14 December 2017

File No: R/2017/11/A and R/2017/14/A
Our Ref: 2017/626594

SSD 8517 and SSD 8449 – Australian Technology Park, Locomotive Workshop

4 SIGNAGE KEY PLAN - BAYS 1-4A
1 : 750

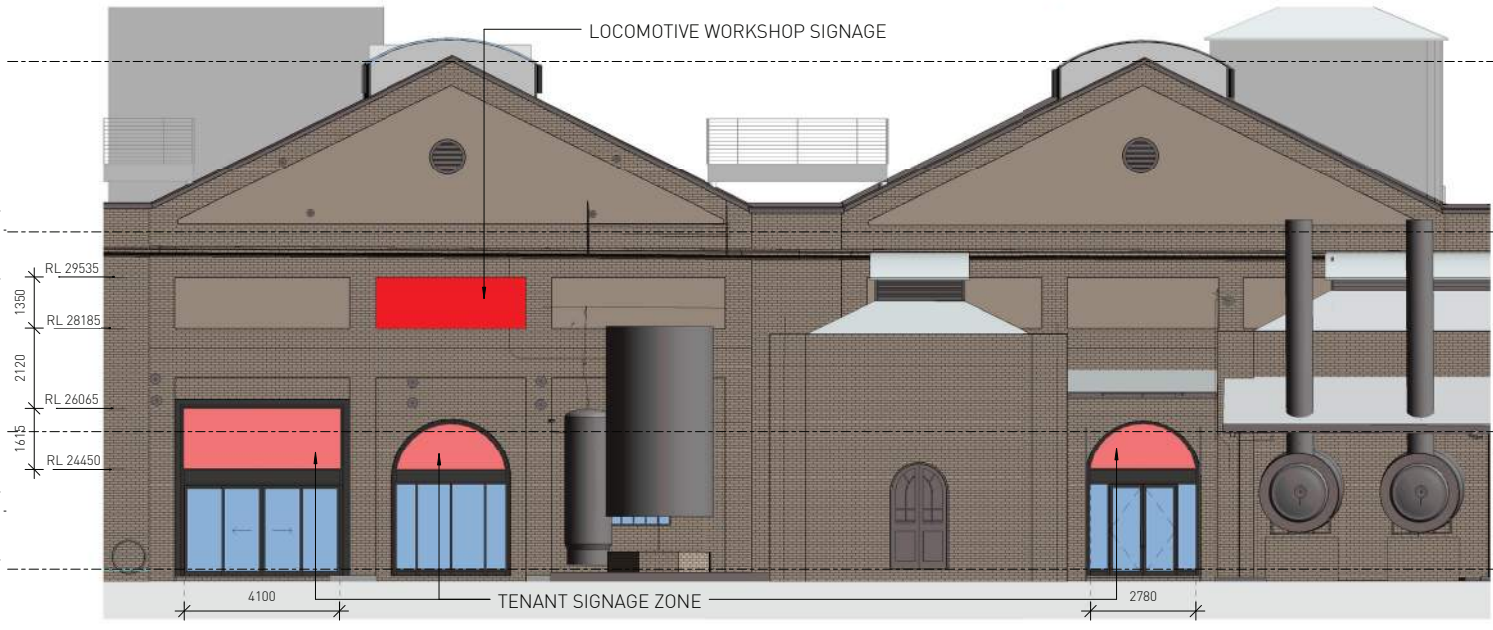
The signage zones generally appear to be appropriately scaled and the strategy appears well considered. However, the zones proposed to the external structures at Bays 4 and 4A appear to cover a considerable surface area that will dominate the scale of these built structures. The City questions the necessity for the signage in that location given that the external structures at Bays 4 and 4A will not have a direct connection with particular tenancies and therefore should be deleted from the proposal.
